Re: CCCC Signage Master Plan

This letter is intended to serve as a letter of approval concerning a revised signage master plan submitted via email on March 3, 2014 for the Cumberland County Civic Center pursuant to condition 6 of the Planning Board approval letter of August 14, 2012. Approval of the signage master plan is subject to a number of conditions which are listed below.

WEST ELEVATION AT SPRING STREET—NAMING RIGHTS WALL ID  
 SCALE: 1/8"=1'-0" NAME RIGHTS ID (3) OF (3)

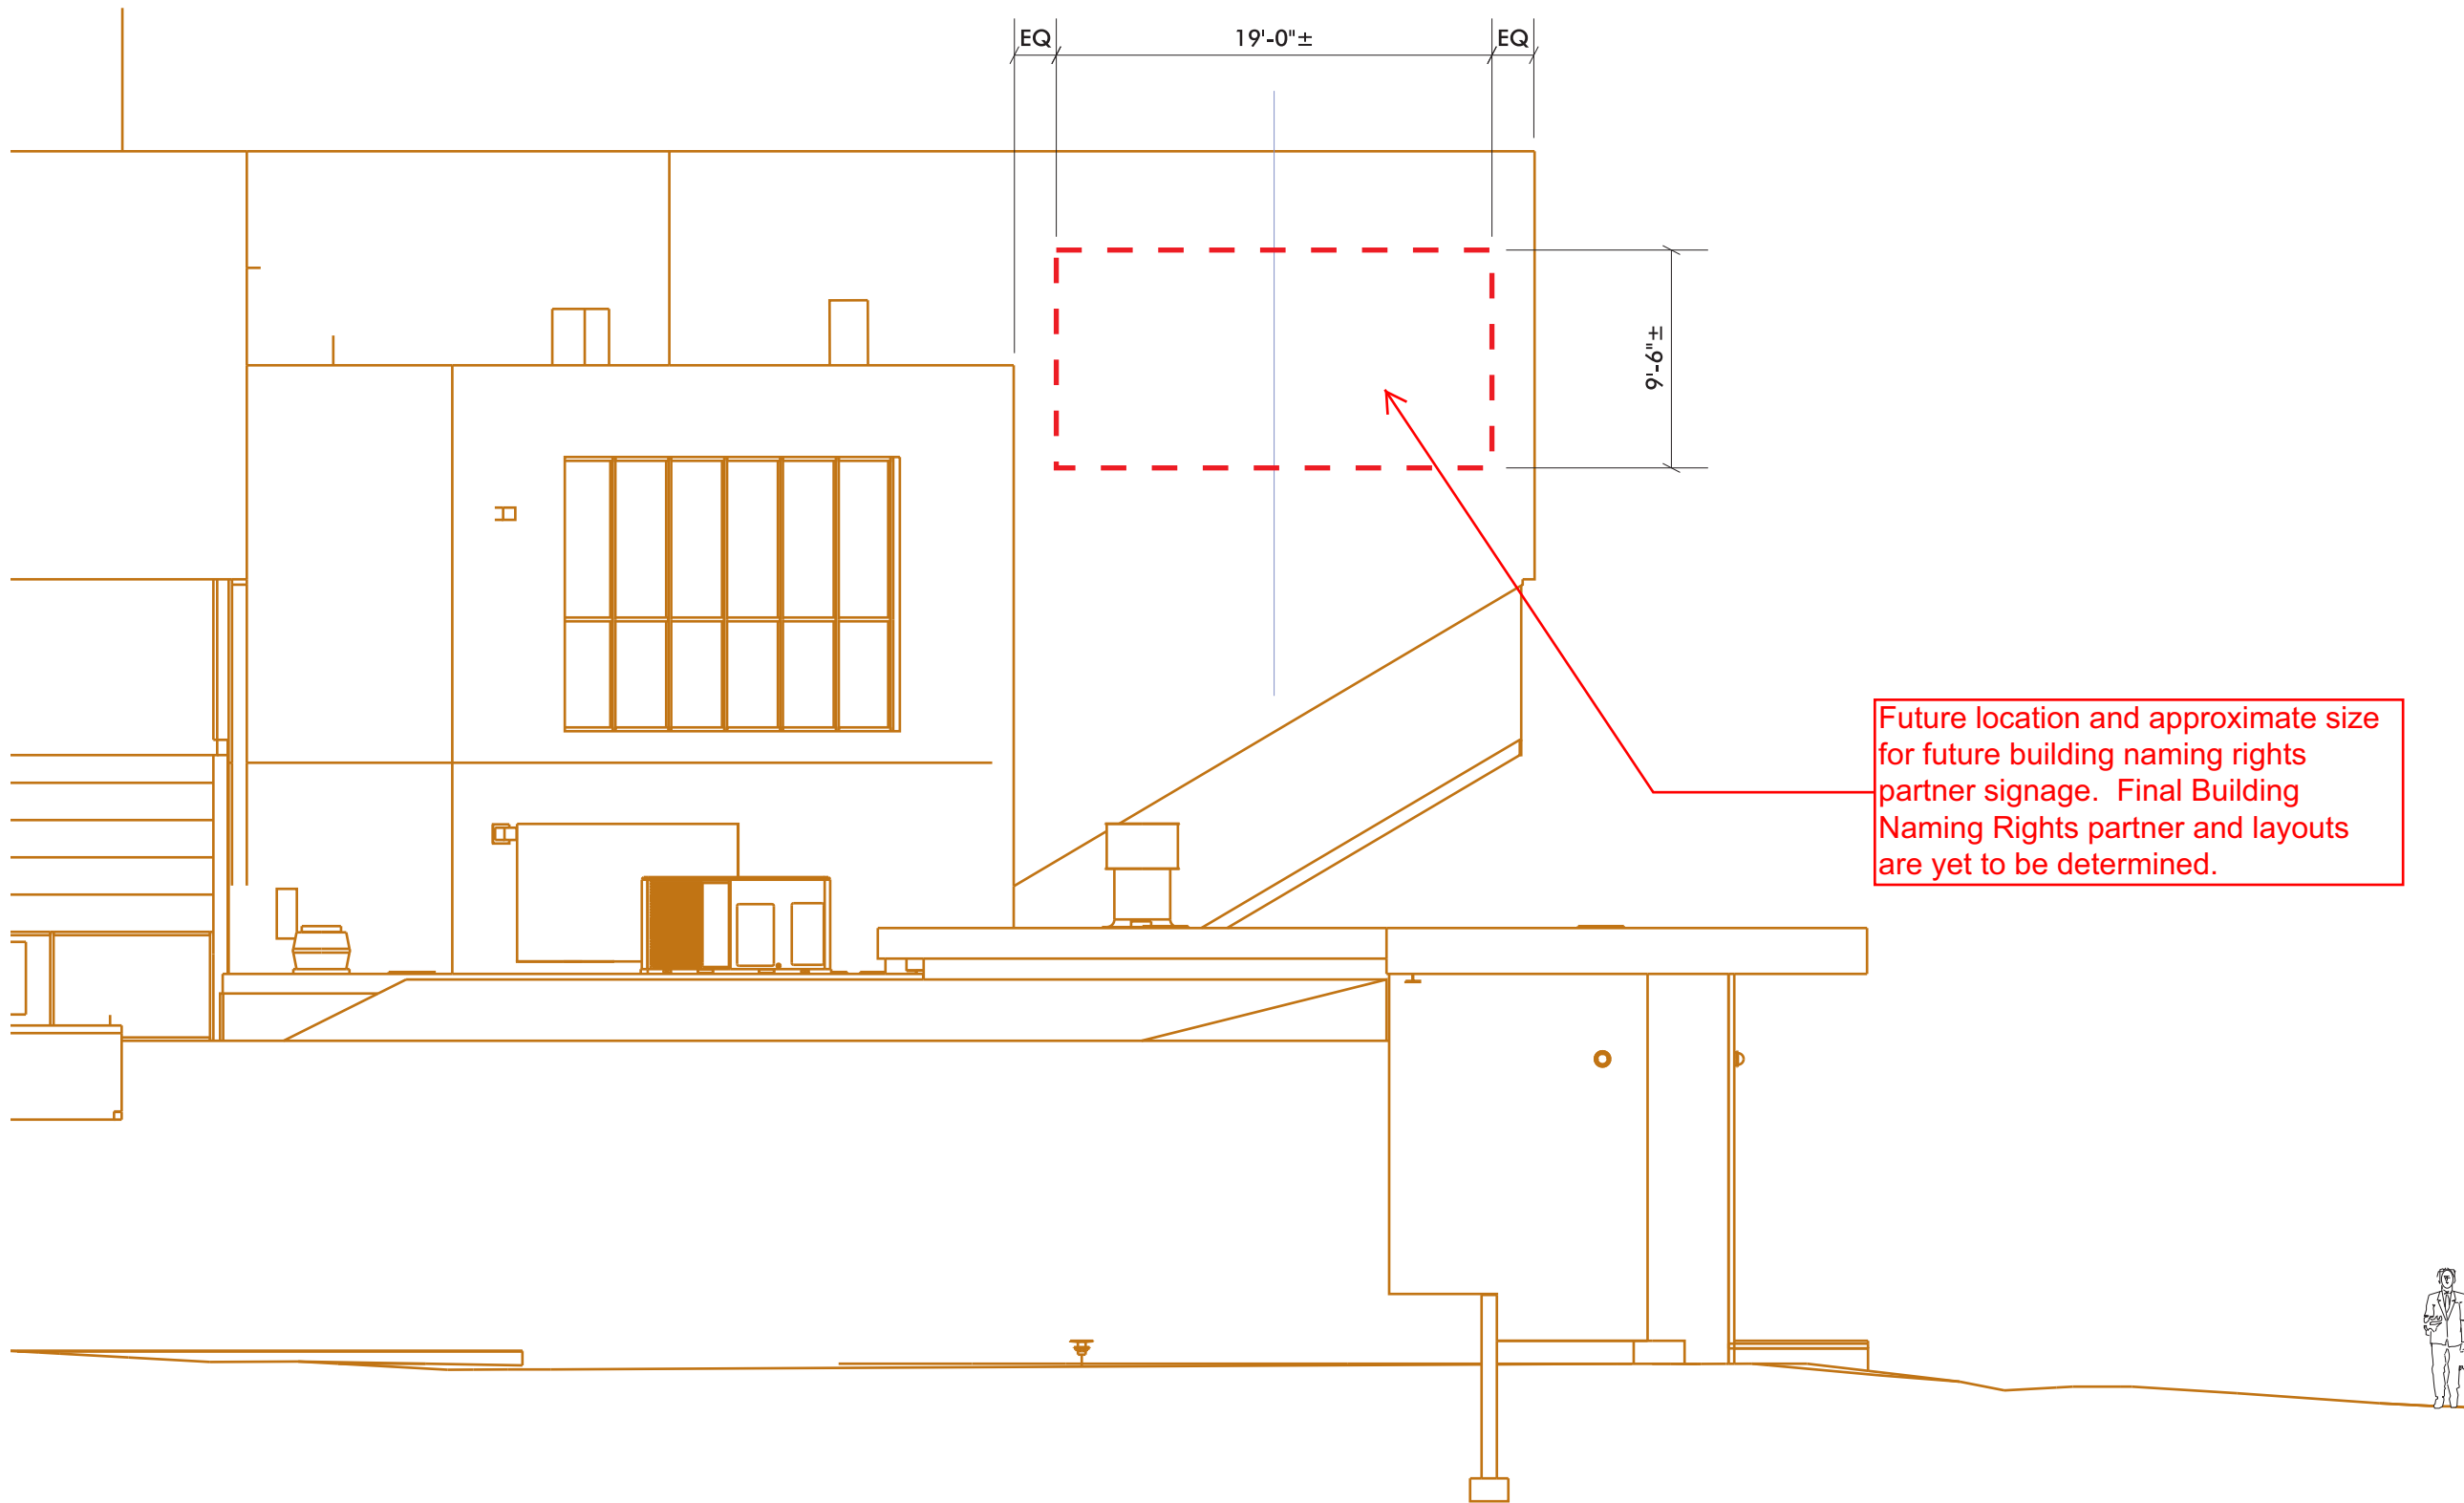
On the upper portion of the CCCC façade the plan references "Future location for building naming rights partner signage". Approval is for the general location of the sign and not the size or the design of the sign. When a specific sign proposal comes forward, the size and design of the sign shall be reviewed by the Planning Authority accordingly. The large existing Cumberland County Civic Center sign along Spring Street shall therefore be removed when a new building naming rights partner sign has been approved by the Planning Authority.
